# CITY OF ALBUQUERQUE

RE: **Old Dominion Freight Line - 330 Airport Road NW**  
**Erosion & Sediment Control Plan** PE Stamp: 2/27/13

File **K10-E008A**

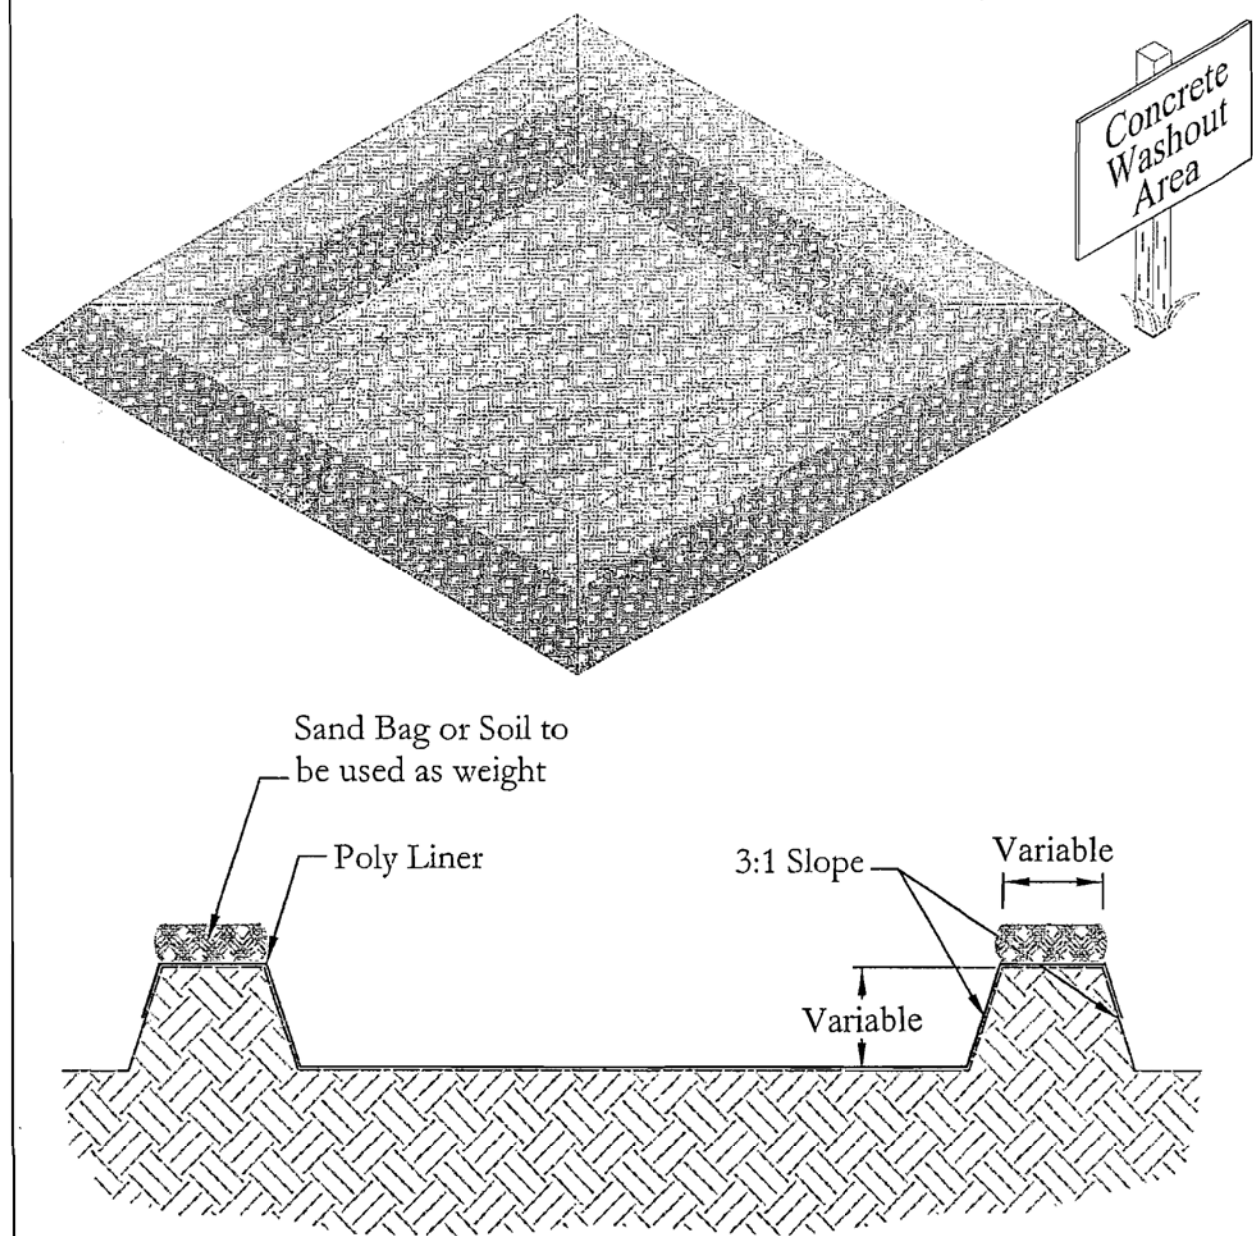
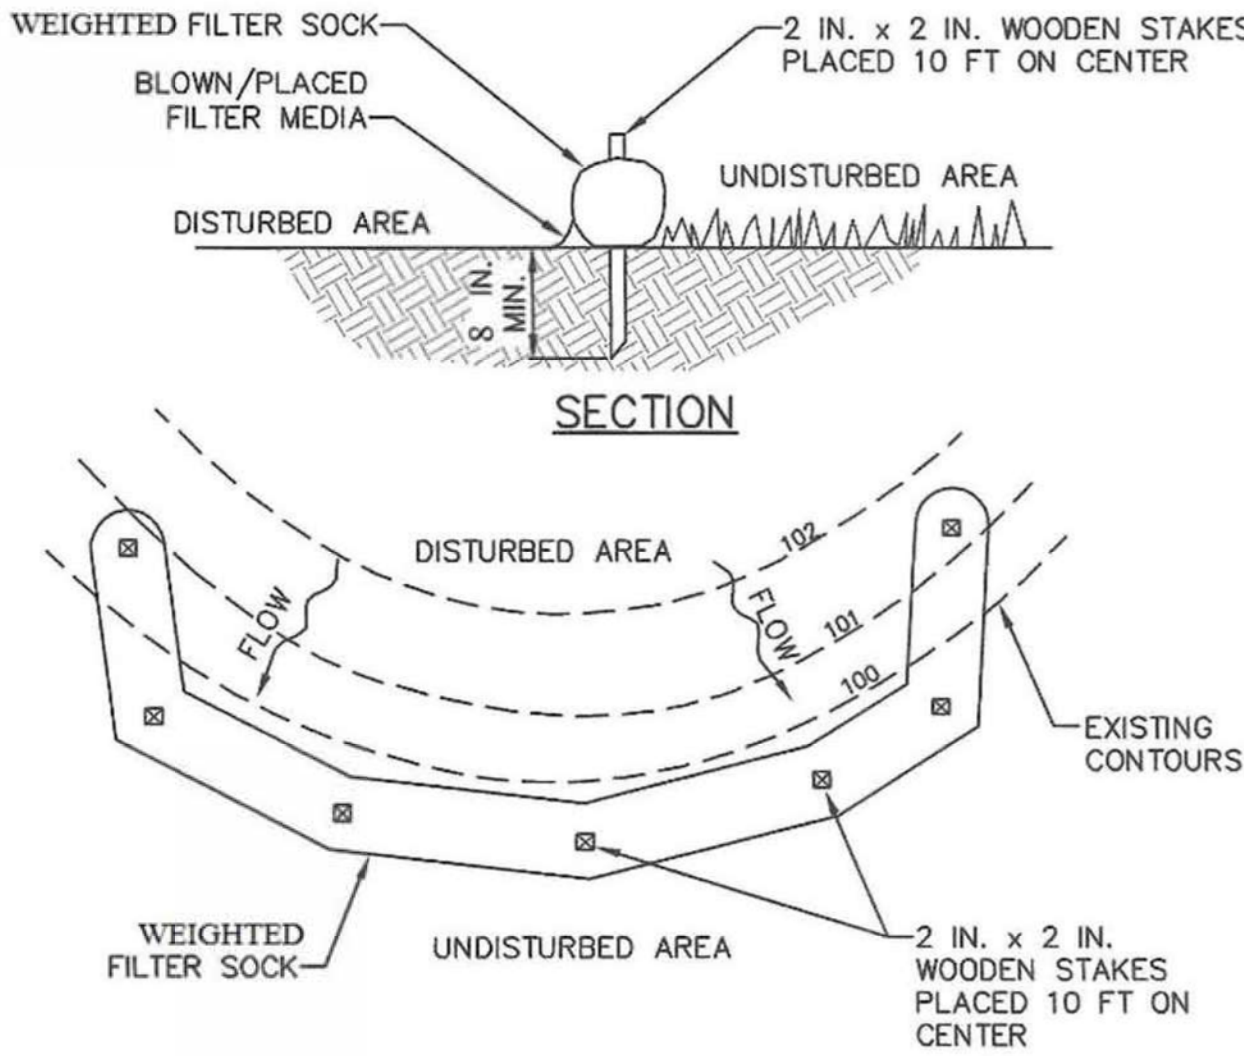
4. Since this site includes a Flood Plane, it seems appropriate to outline and label it on this plan.
5. Drafting standards should generally conform to those outlined in the DPM, Chapter 27. Some of the notes on your BMPs, sheet EC-2, use very small text, which may be illegible at 50% reduced scale.
